Application ref: A/55/21/DOC

Description: Approval of details reserved under condition imposed under A/219/17/PL relating to Conditions 3 - contamination 11- Surface Drainage Water 13- SUDS Management 17 -Hedgerows 18 - Badgers

Location: Land South Of Mayflower Way Angmering BN16 4AY

Summary recommendation: Recommend the discharge of Condition 17 Hedgerows imposed under ref A/219/17/PI on this application A/55/21/DOC

PROJECT TITLE: MayflowerWay Angmering	
PROJECT NUMBER: DD486	PLOT DATE: 03.02.21
DRAWING SCALE: 1:200	APPROVED BY: PD
PAPER SIZE: A1	DRAWN BY: JT
DRAWING TITLE: Existing Hedge Retention and Enhancement Plan - Condition 17

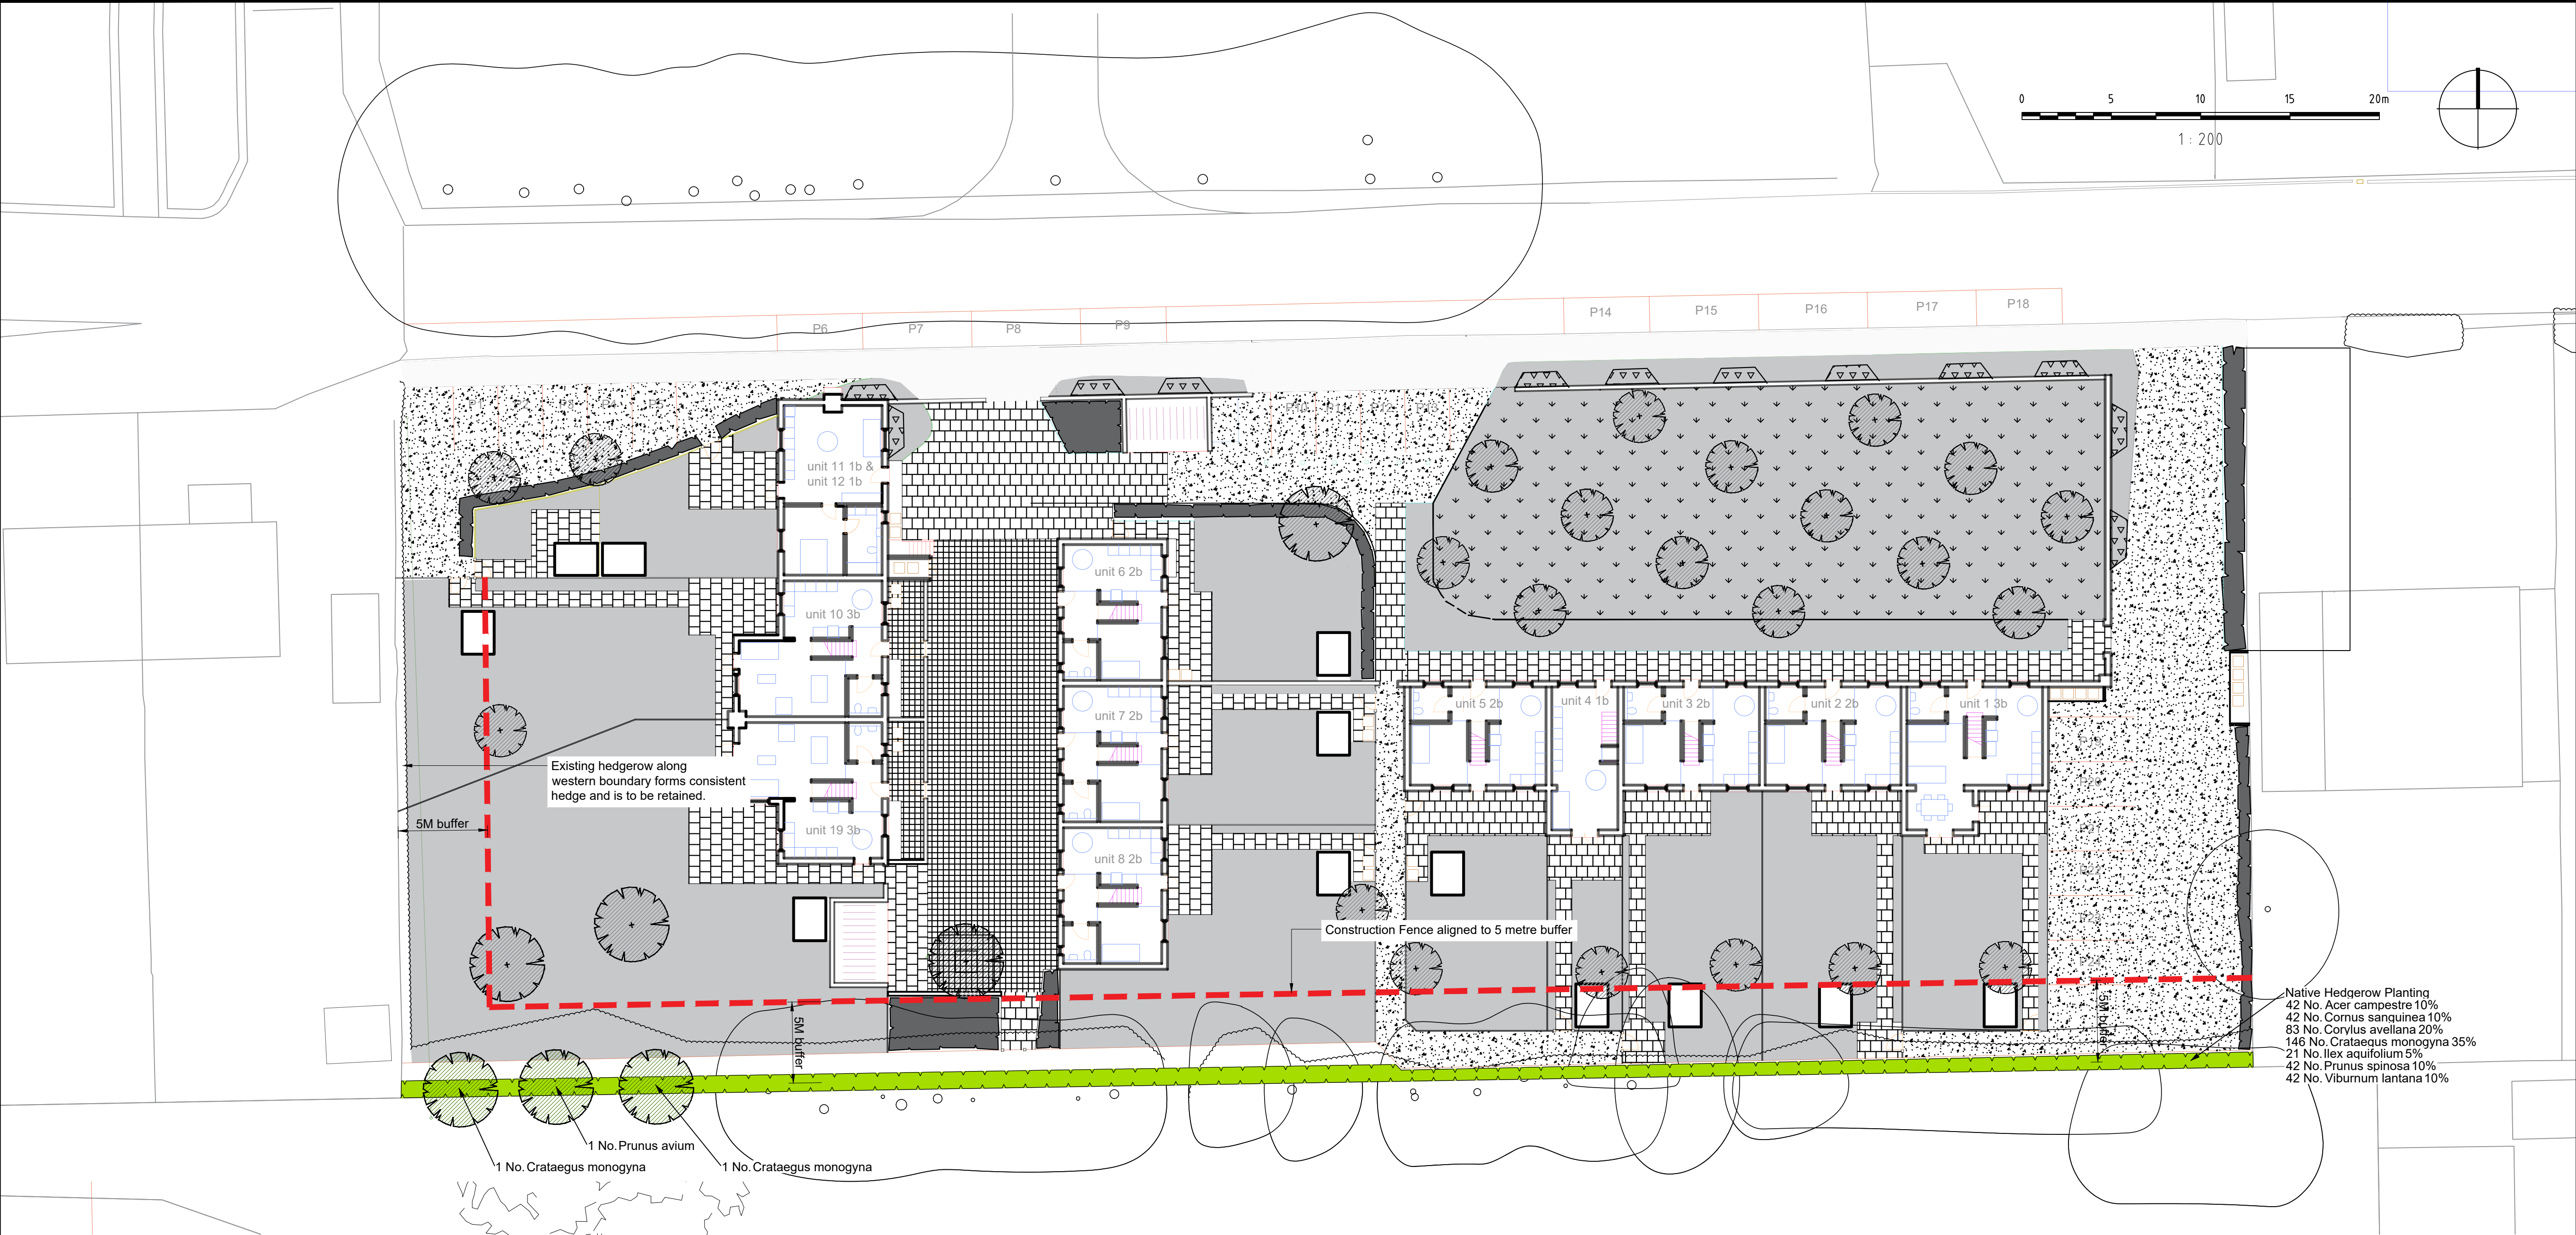
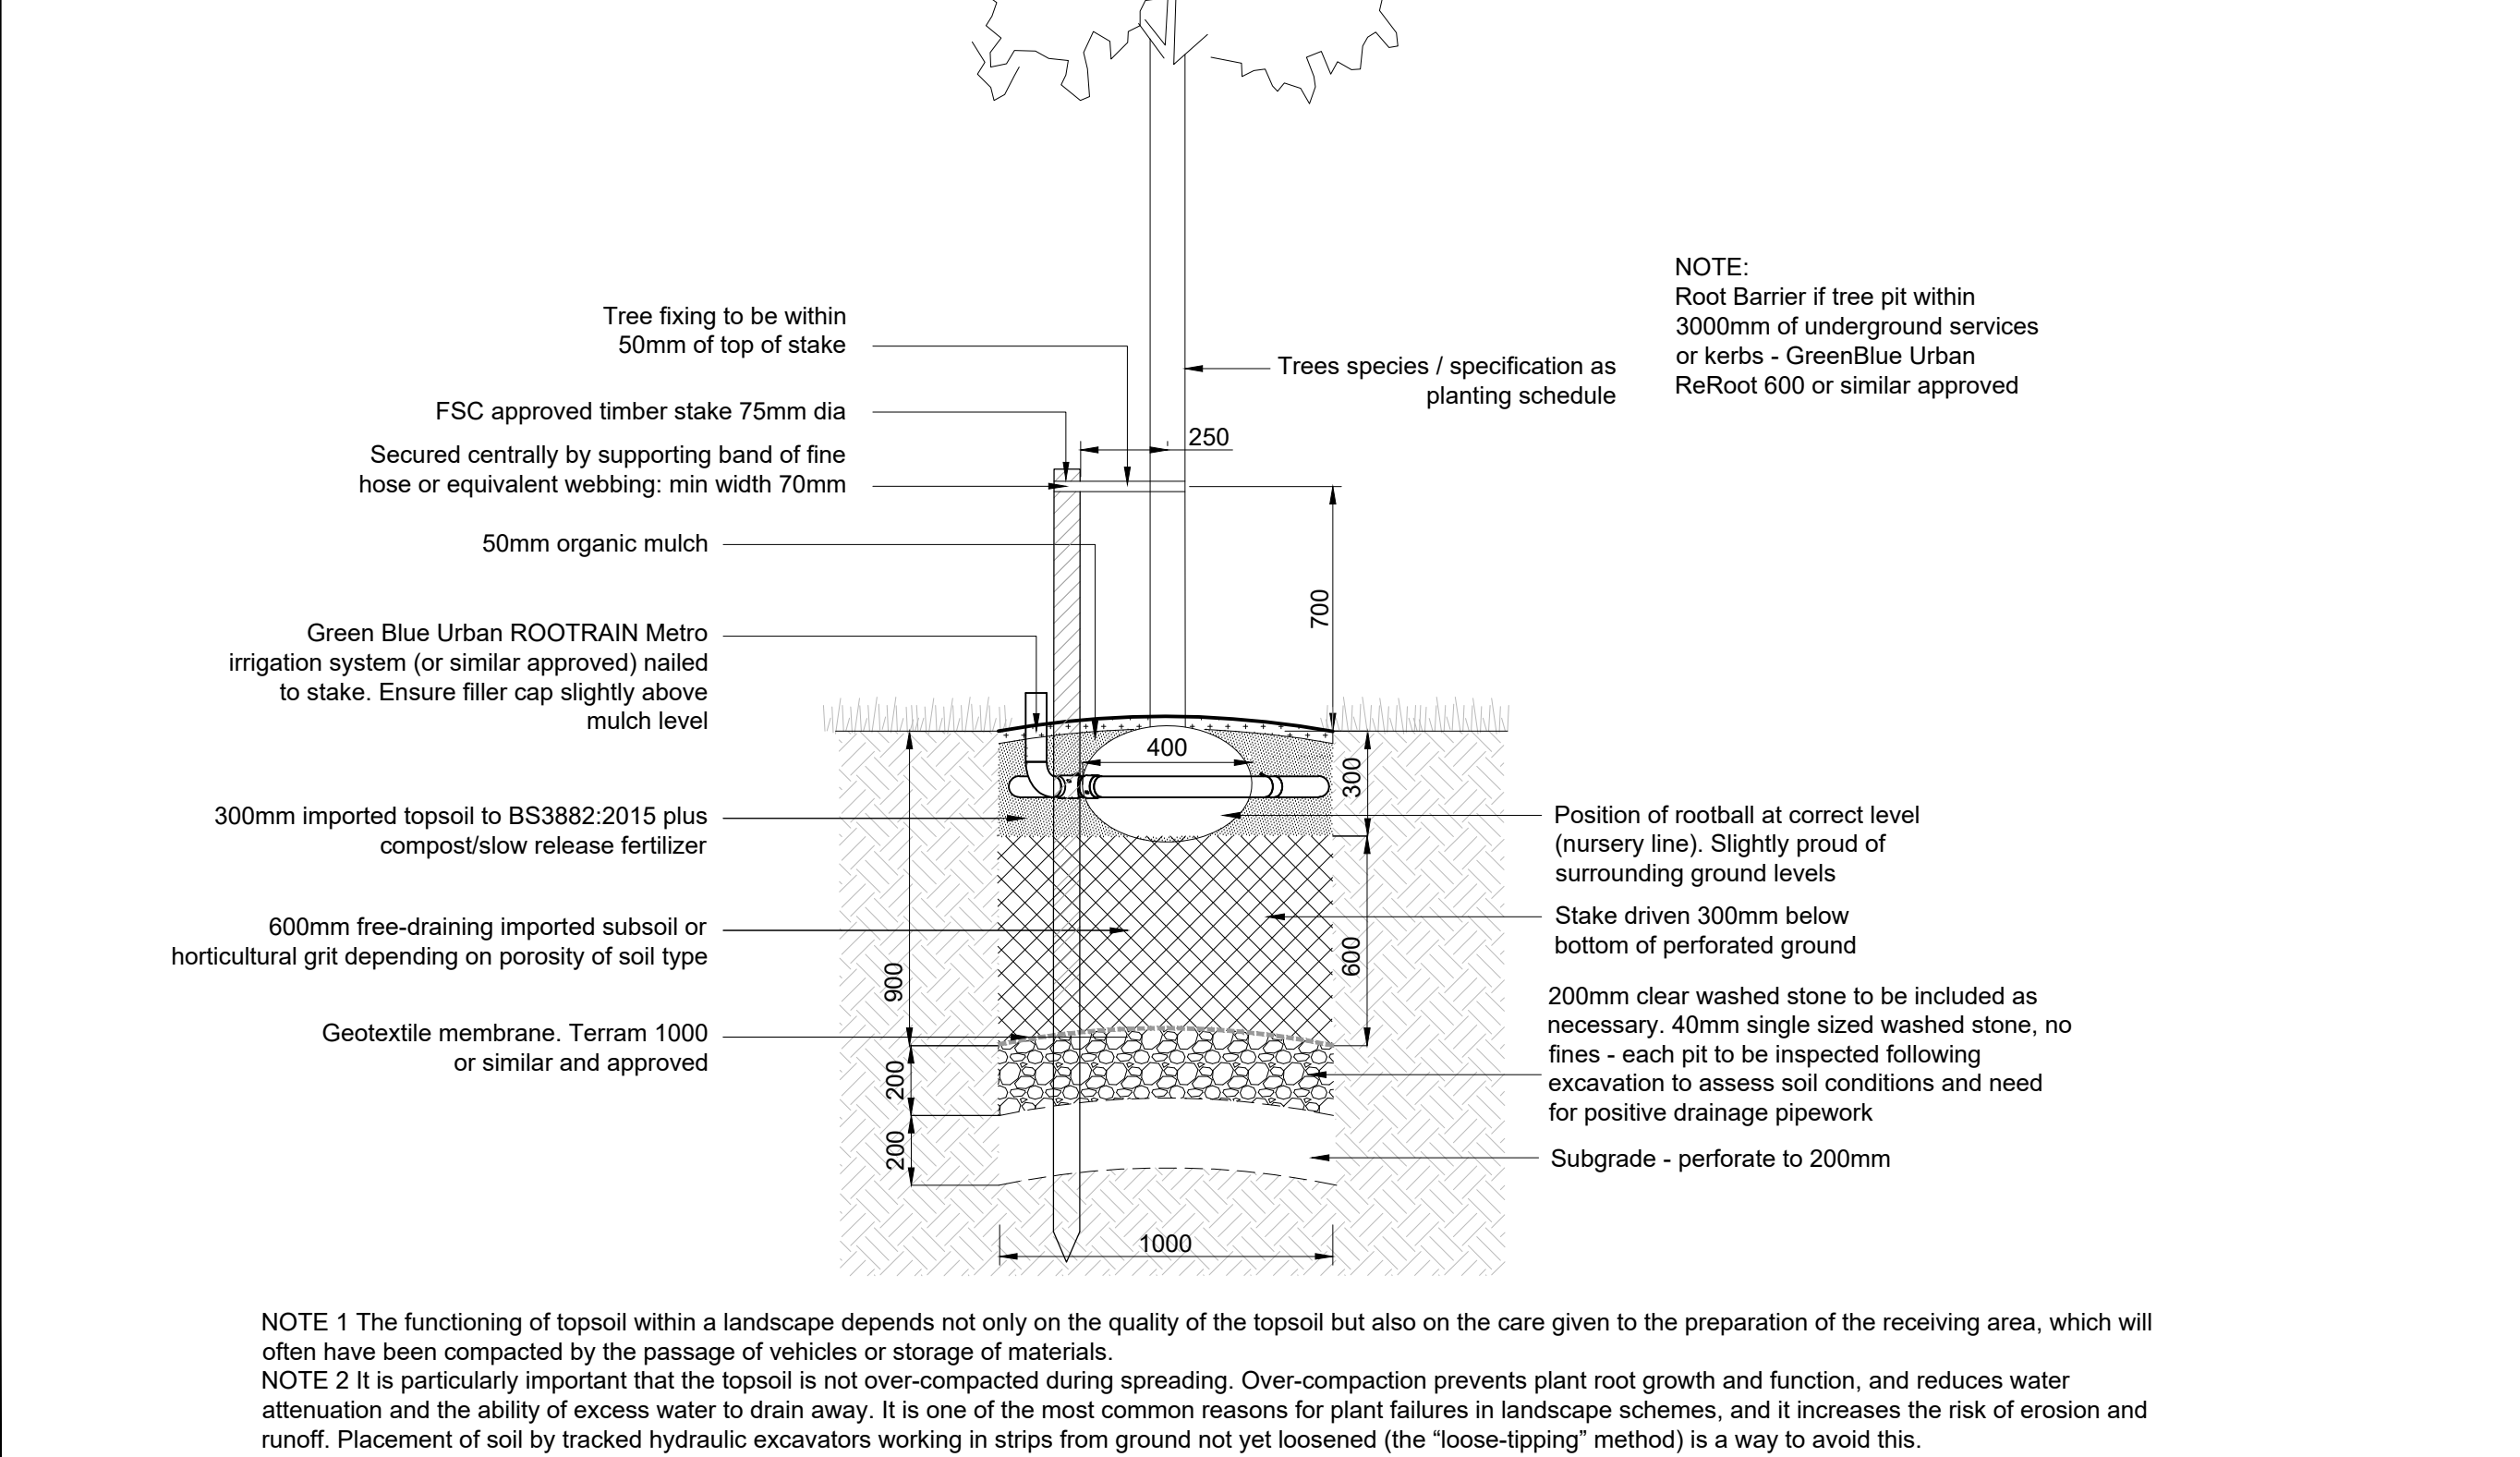
Comprehensive detail has been given within the drawing Existing hedge retention and enhancement plan Condition 17 which has detailed and shown the new planting proposals. The detail has provided a good representation of existing features, retention details of existing vegetation and indicated improved habitat formation.

The information provided would provide a scheme suitable and fitting for location, with detail of quantities, species, and planting densities at time of planting.

Recommend the discharge of Condition 17 Hedgerows imposed under ref A/219/17/PI on this application A/55/21/DOC
